MEMORANDUM

To: FILE
From: Nell Donaldson
Subject: Application ID: 2015-060
Date: 5/12/2015

Comments Submitted by: Keith Gautreau/Fire on 4/27/2015

Title: LAYOUT AND LIGHTING PLAN

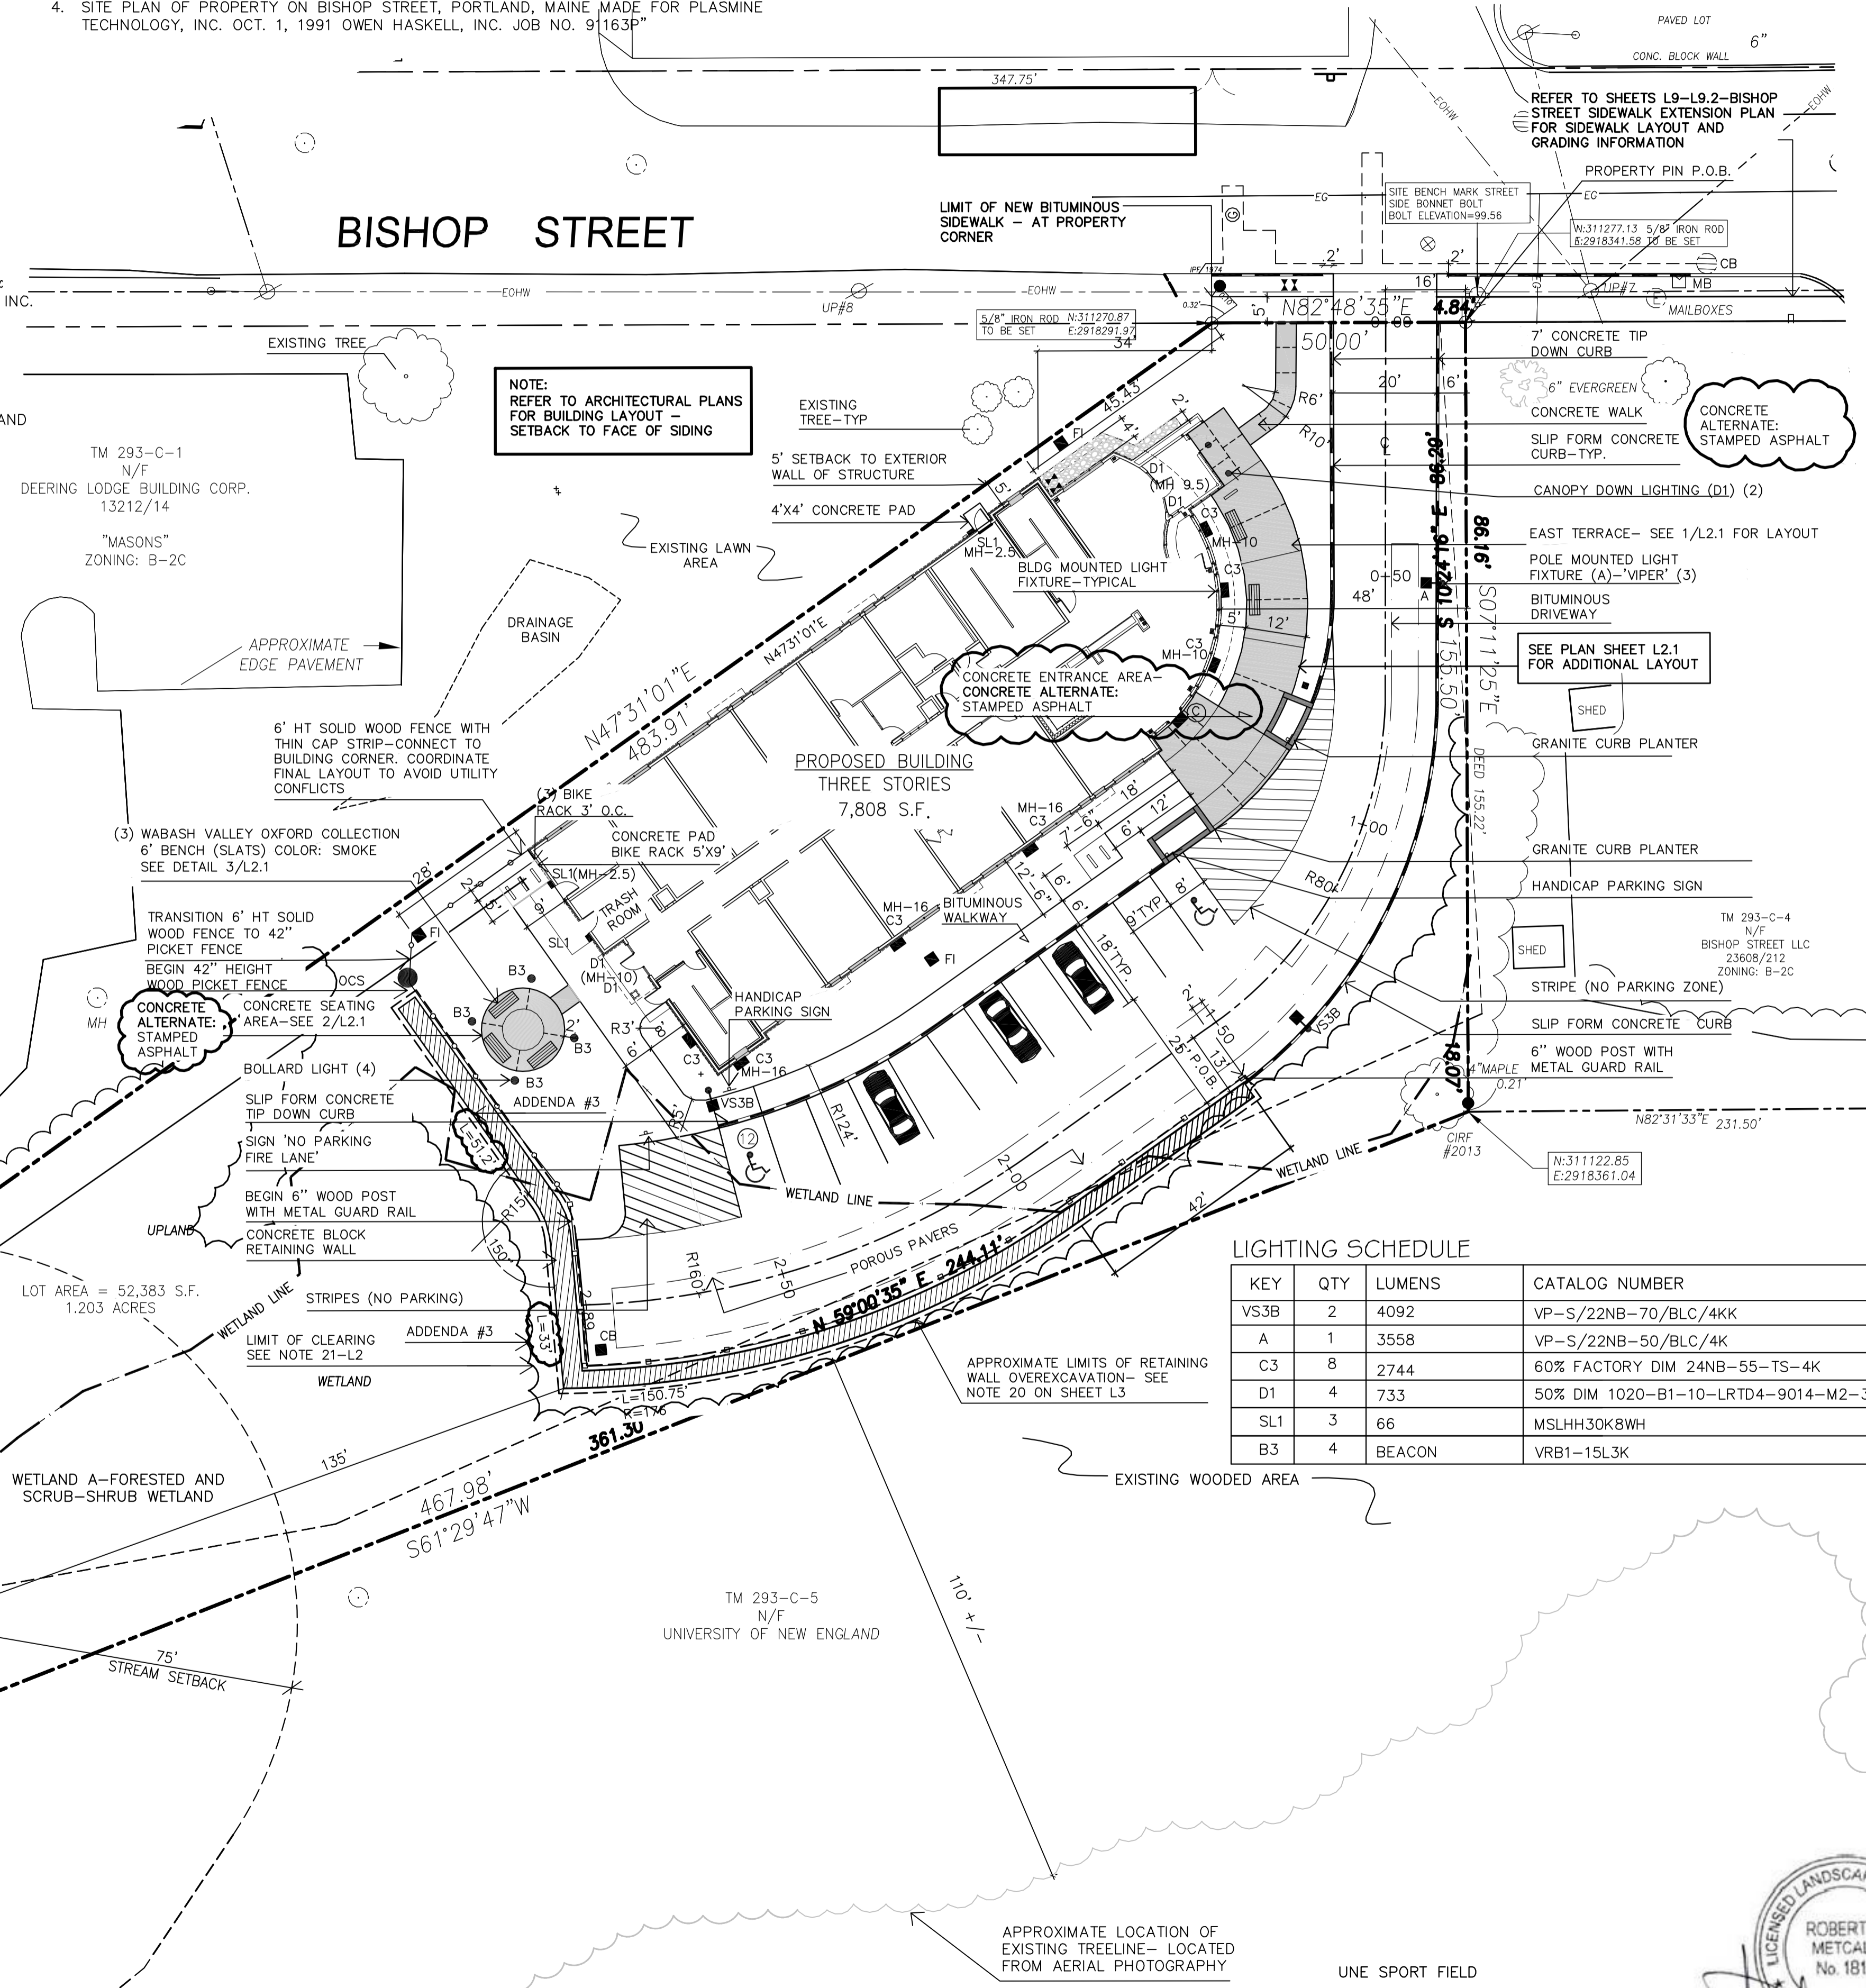
Hydrant location looks good. (same side of street)

Access to three sides of building is acceptable. Would like to see "No Parking Fire Lane" adjacent to proposed striping in parking lot.
